HOMESTEAD NORTH AT STERLING RANCH FILING 2

GRADING AND EROSION CONTROL PLAN

HOMESTEAD NORTH AT STERLING RANCH FILING 2
COVER SHEET

PROPOSED DRAINAGE MAP

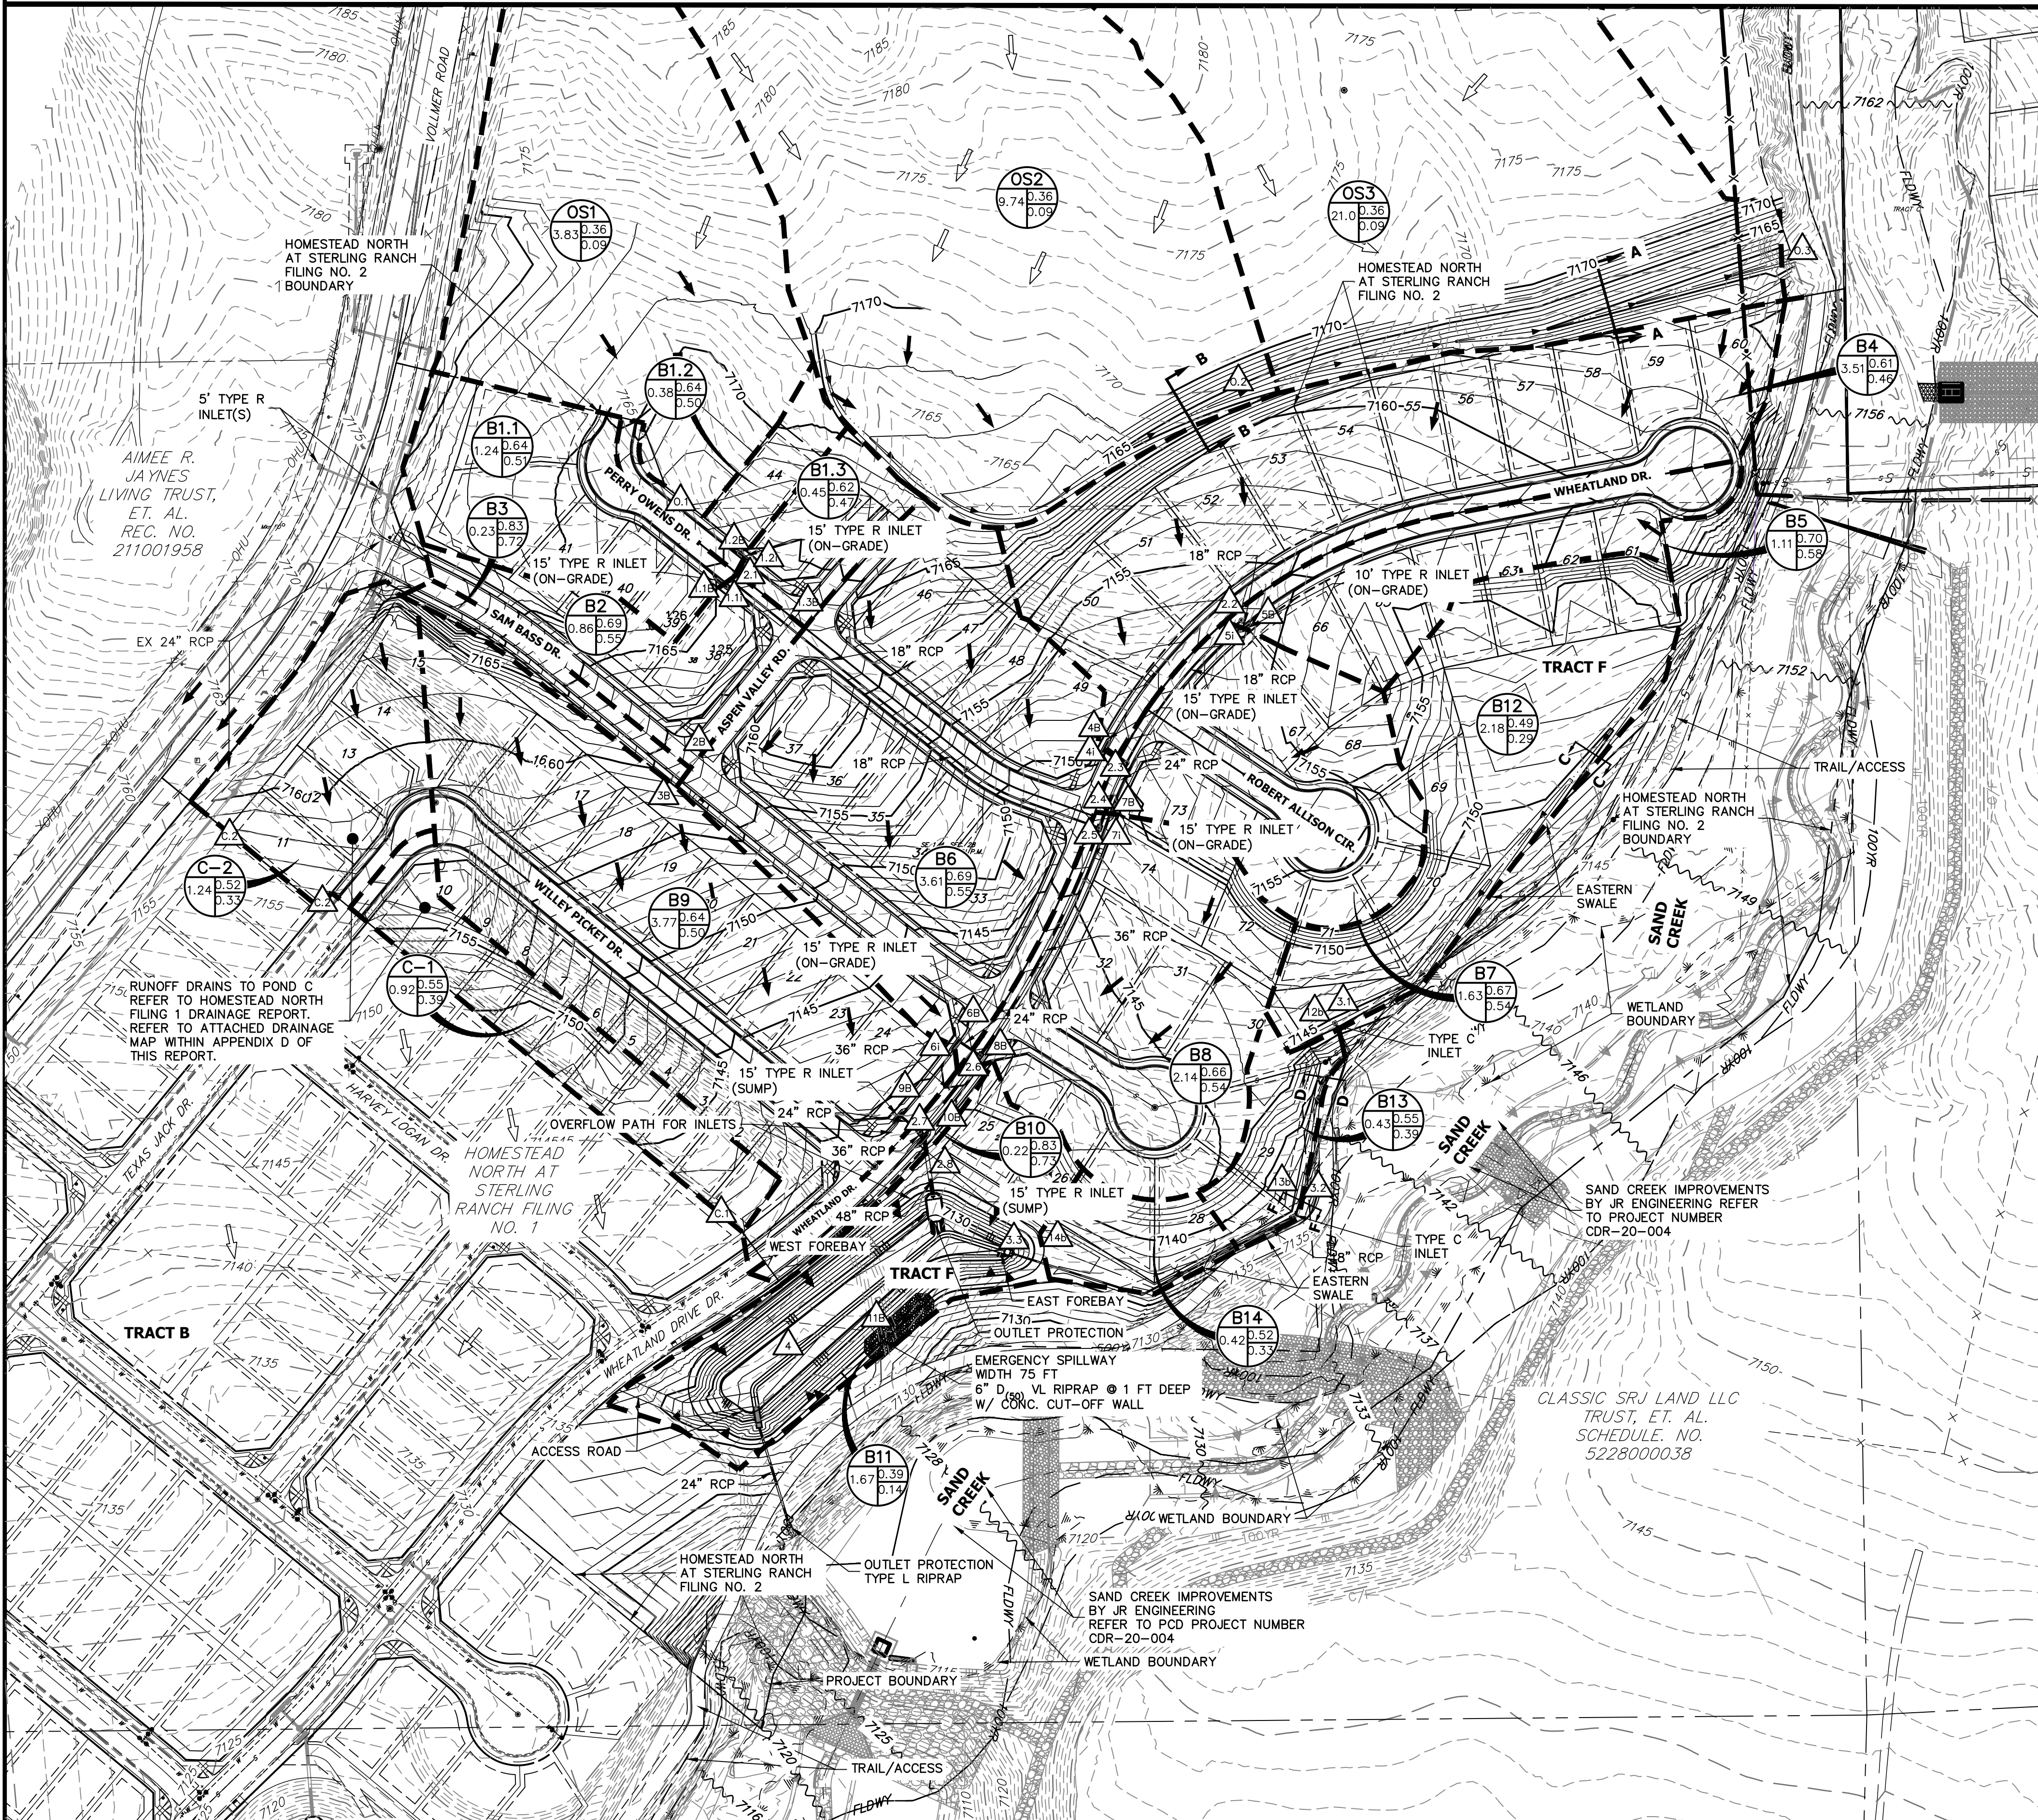
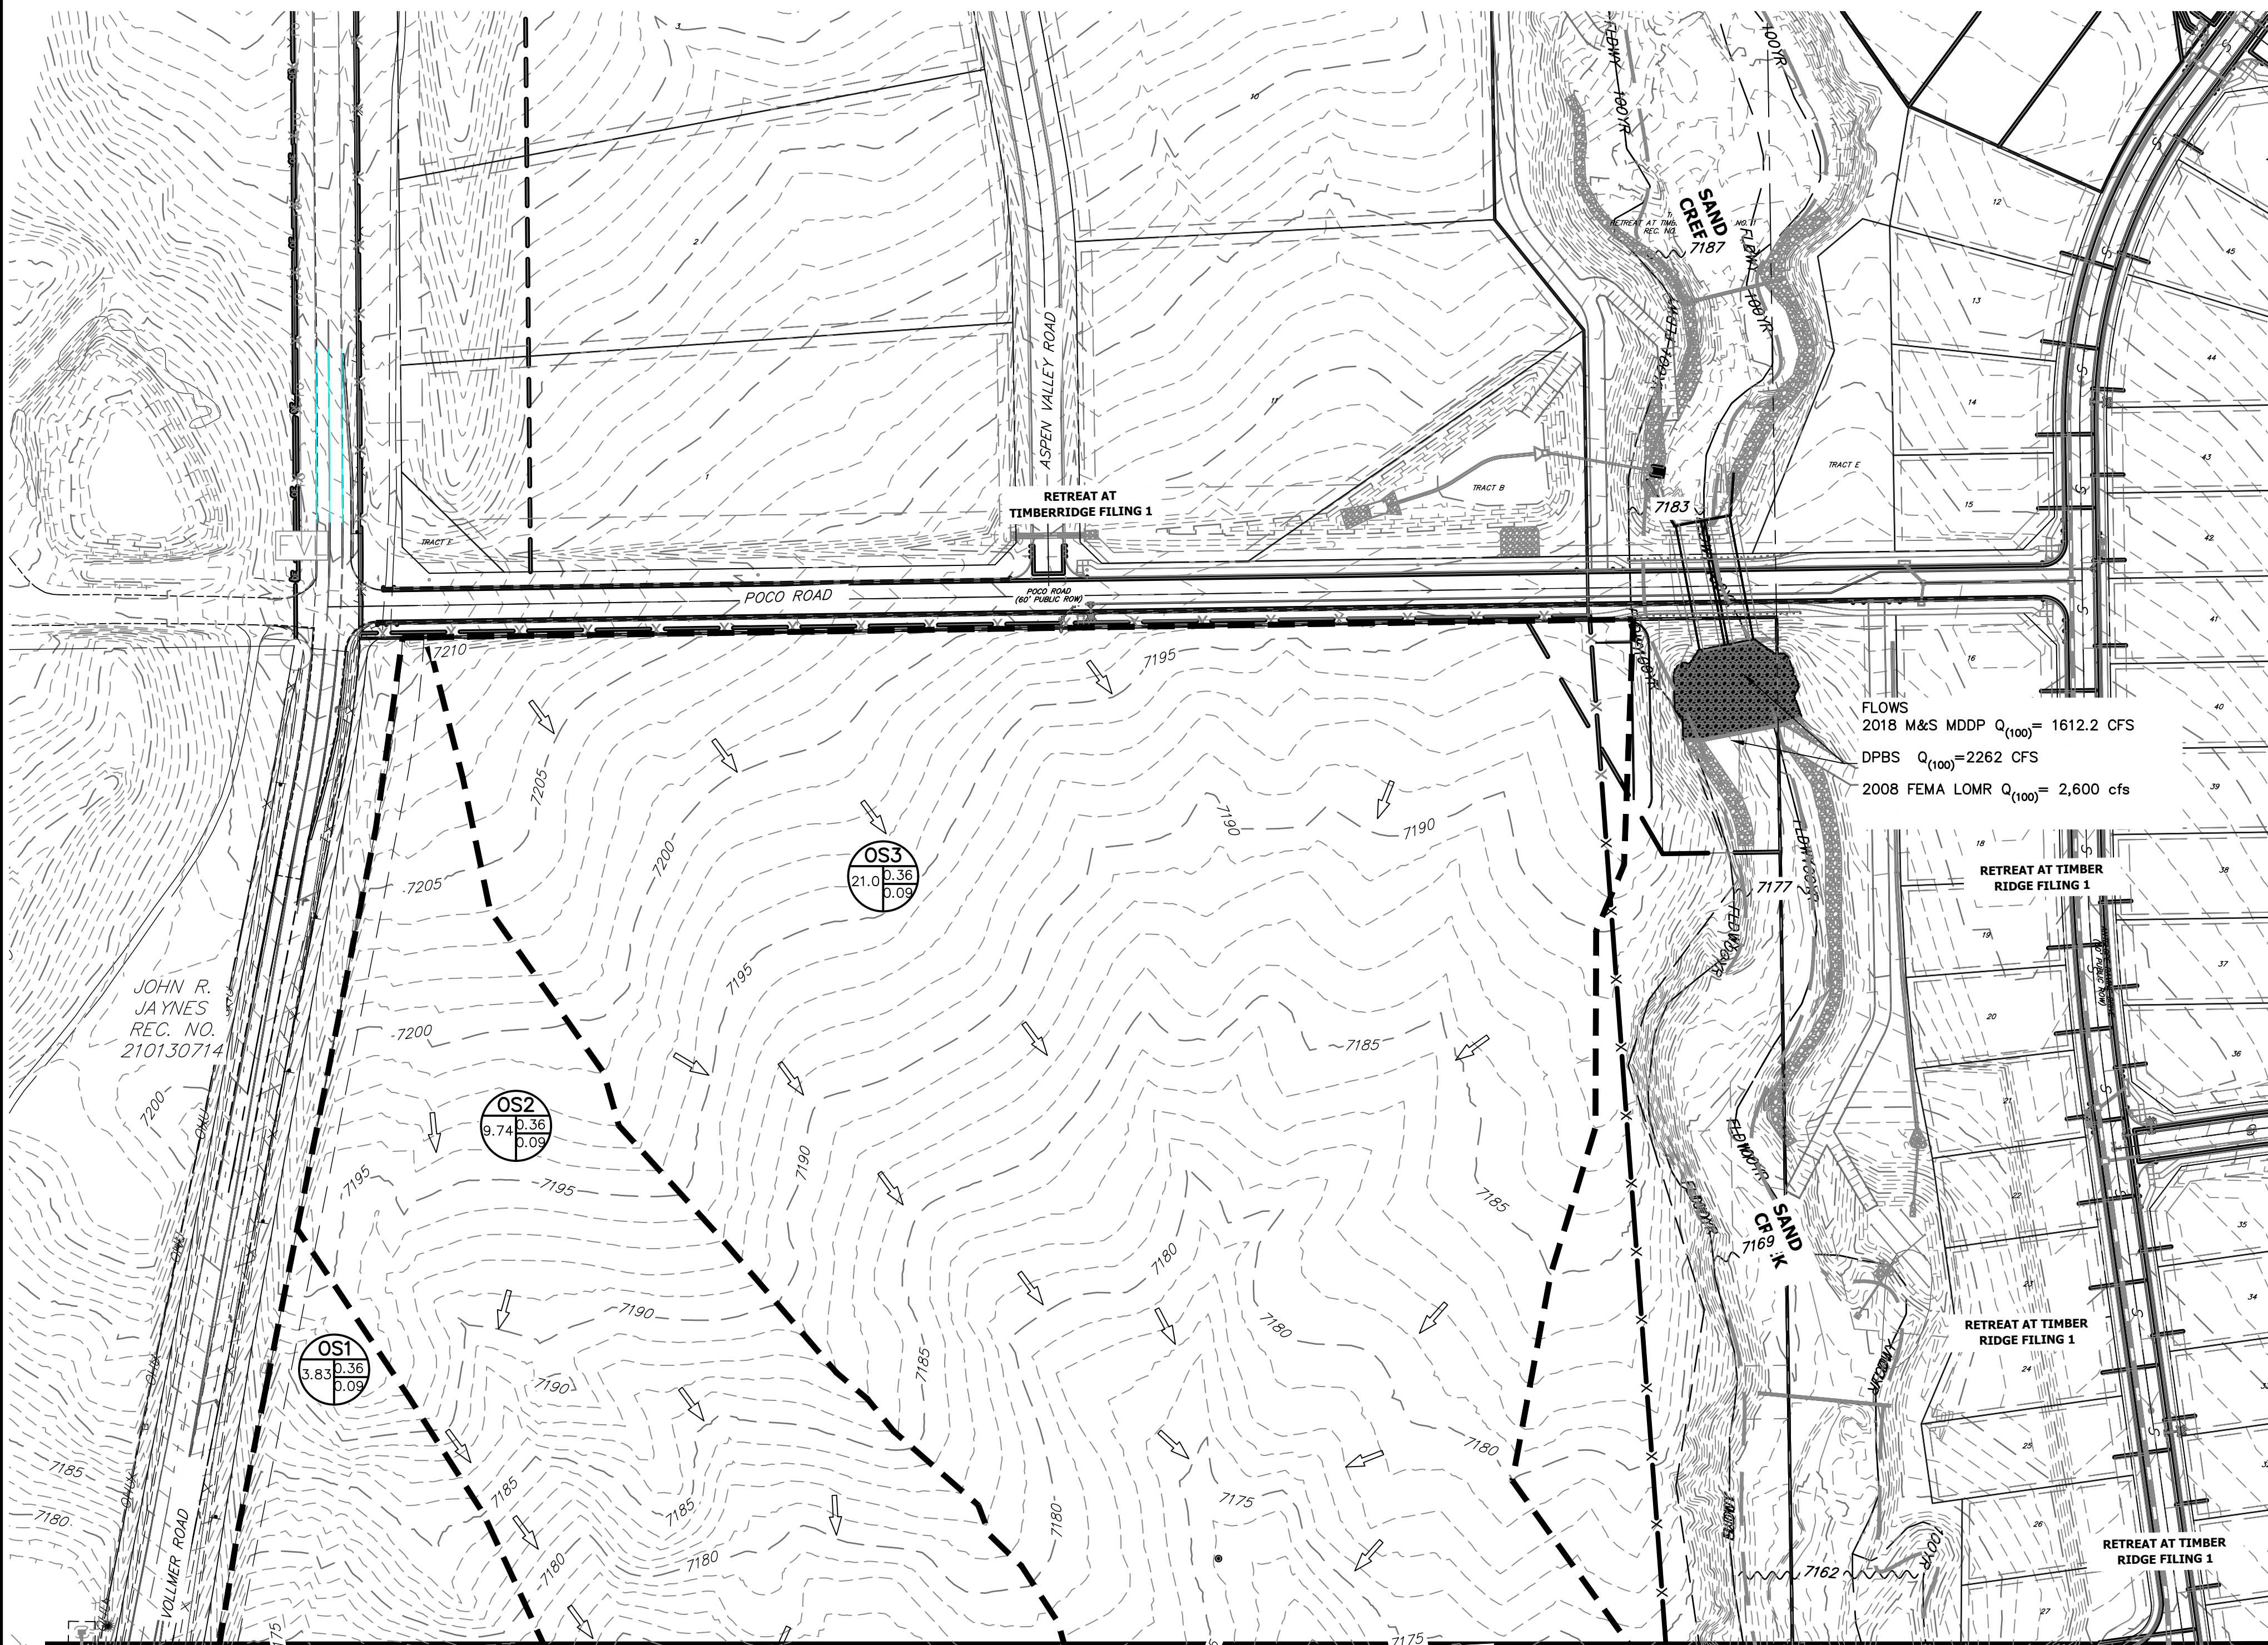
Update swale details to match those shown on proposed drainage map in HN F22 PDR

Addressed: FDR and GEC swale details are now correlated
